HCI ENGINEERING

Re: Responses to Conditions of Approval – Dated May 13, 2016
Project: HCI 15-34 Taco Bell at McMahon Marketplace

The following letter addresses the comments from the Official Notification of Decision.

TOTAL AREA THIS ELEVATION: 623 S.F.

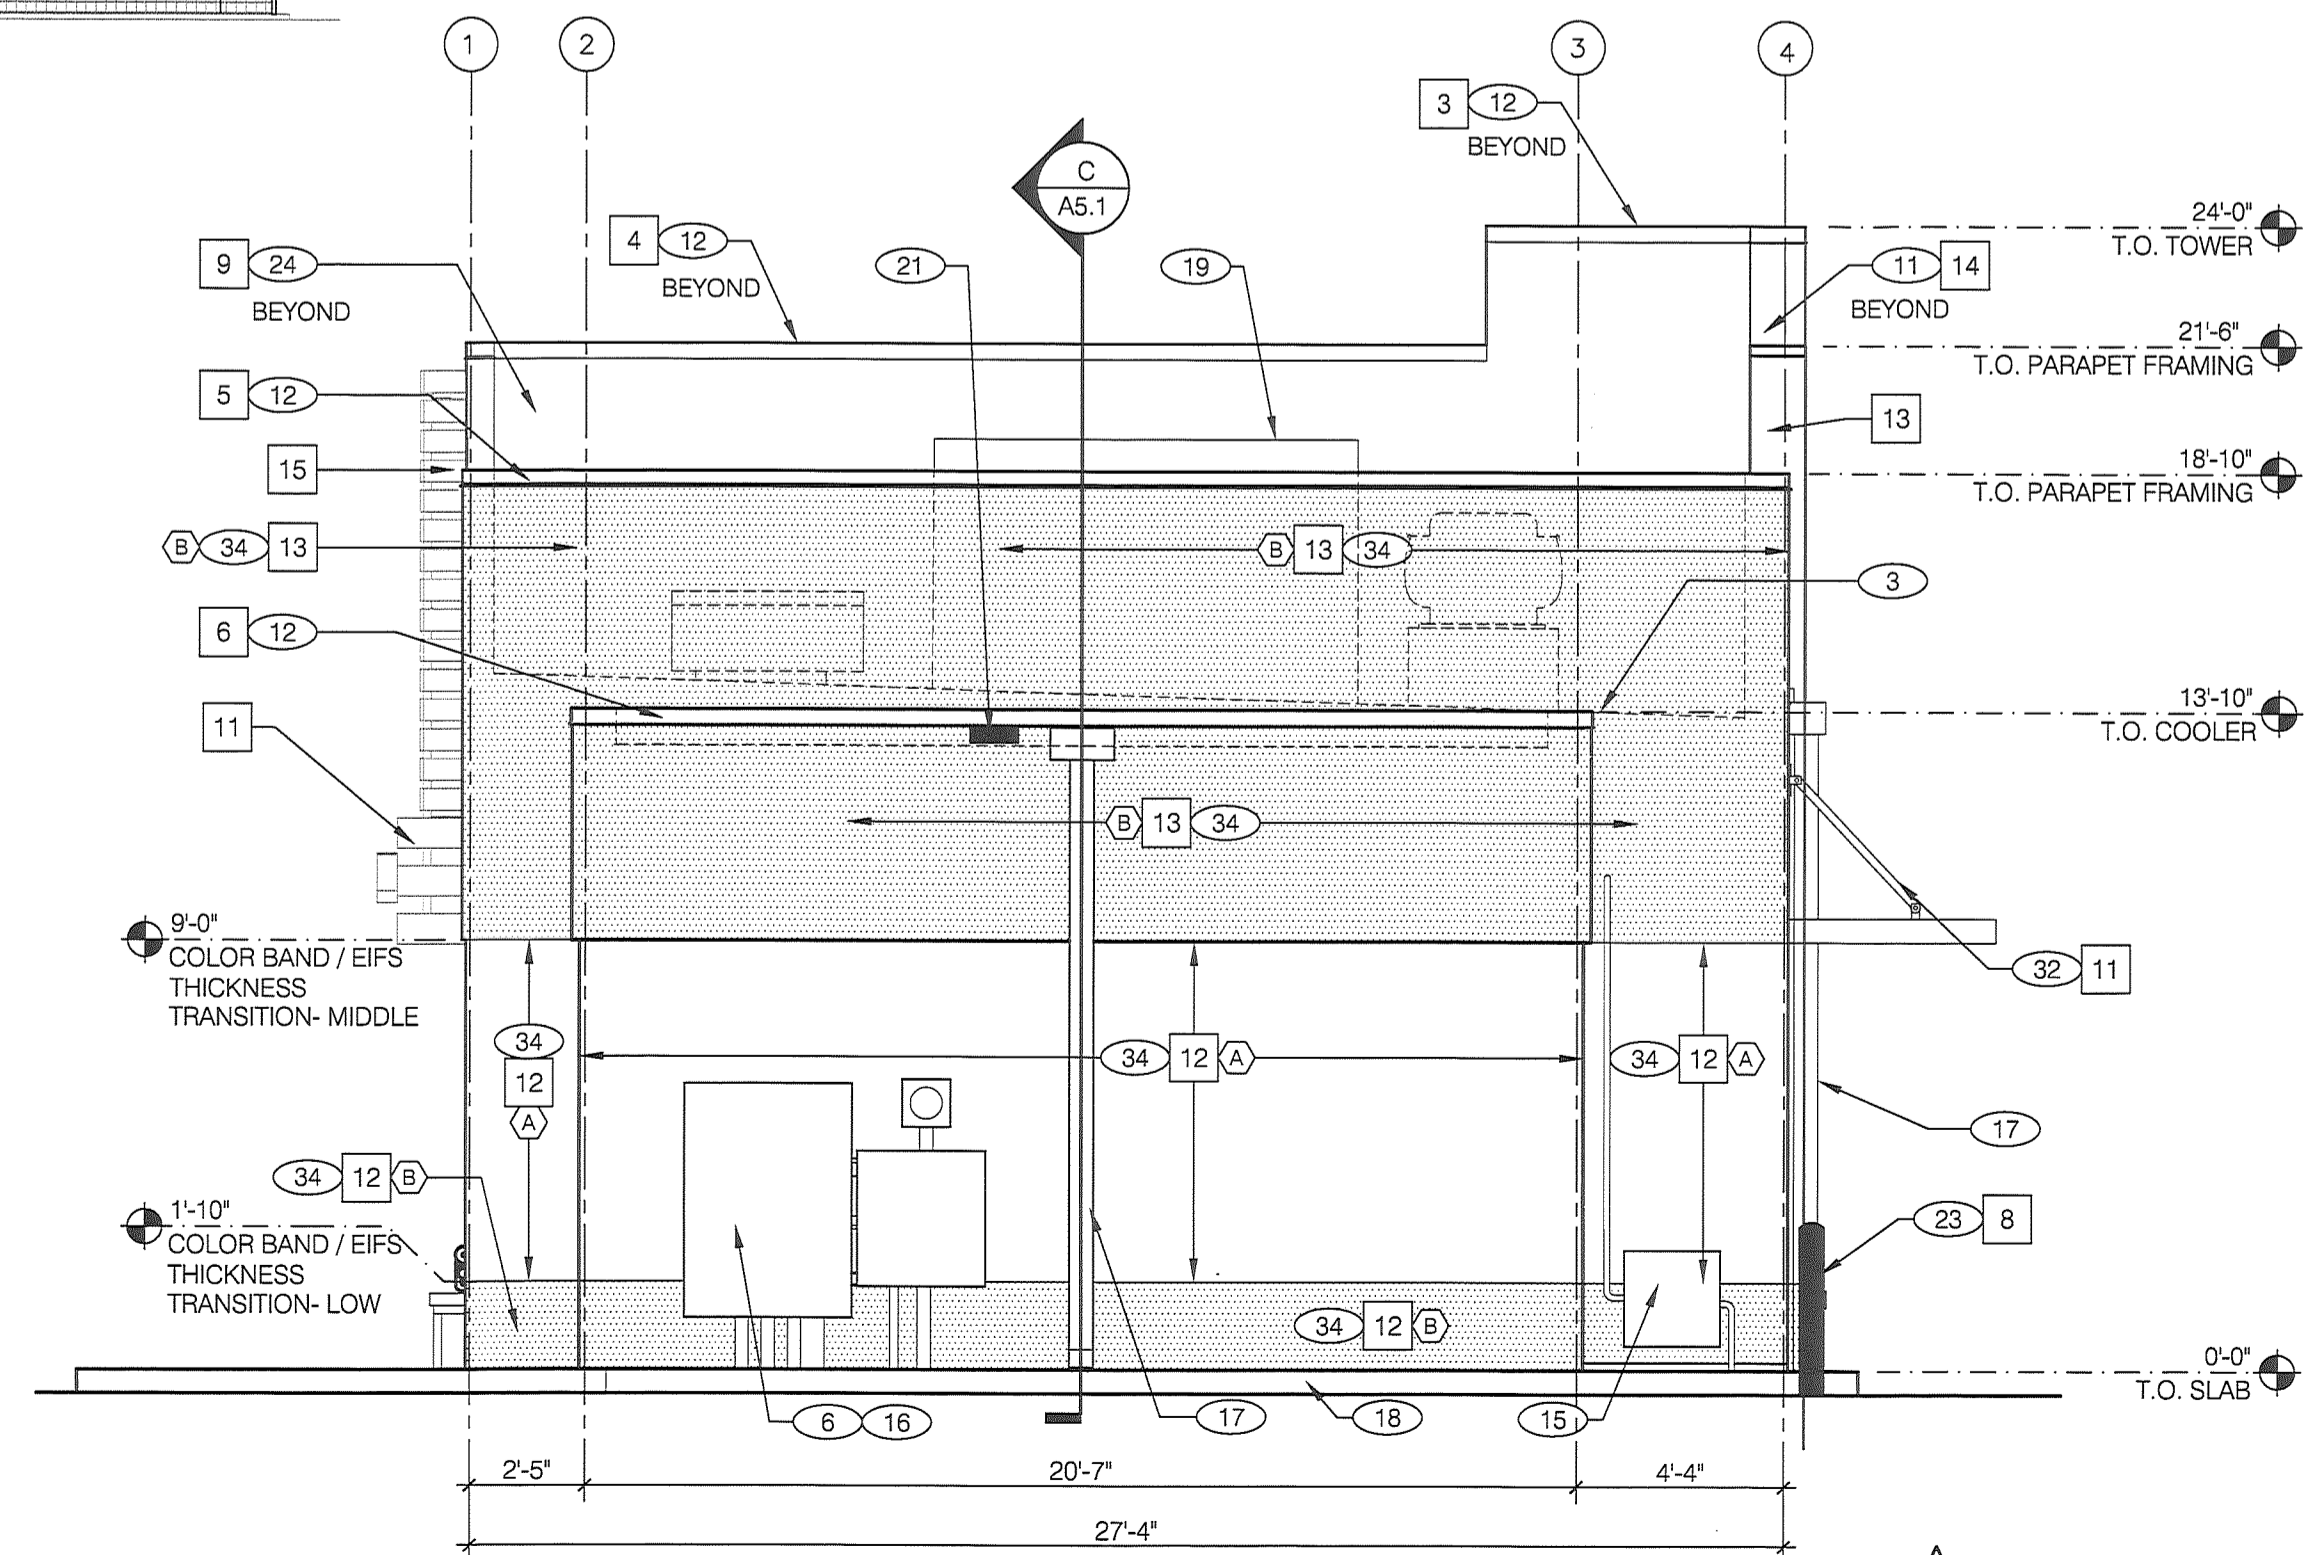
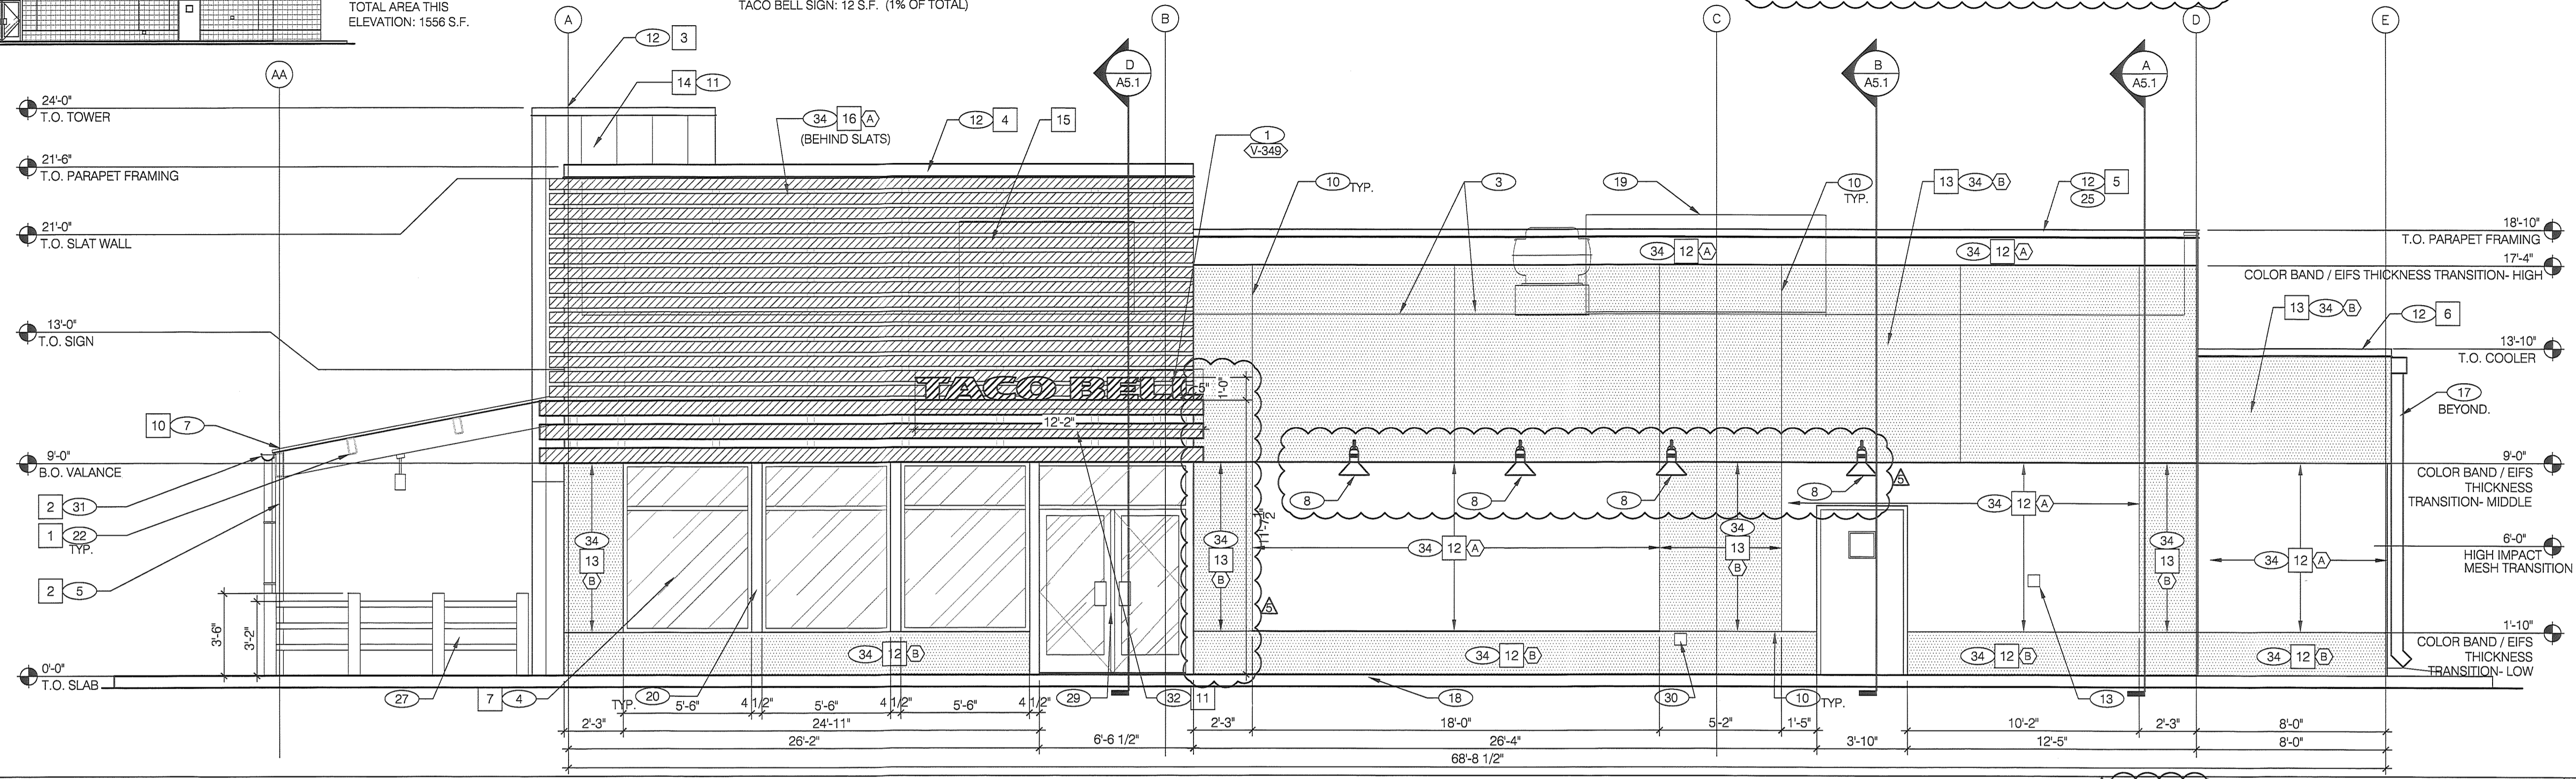
- a. The building mounted signage on the western elevation shall be reduced from 6.8% of façade to comply with the 6% of façade limitation (Standard I.2.a.1).

- g. Label the elevations using directions (Sheets A4.0 and A4.1)

Response: The signage has been reduced.

Response: The elevations have been labeled with directions.
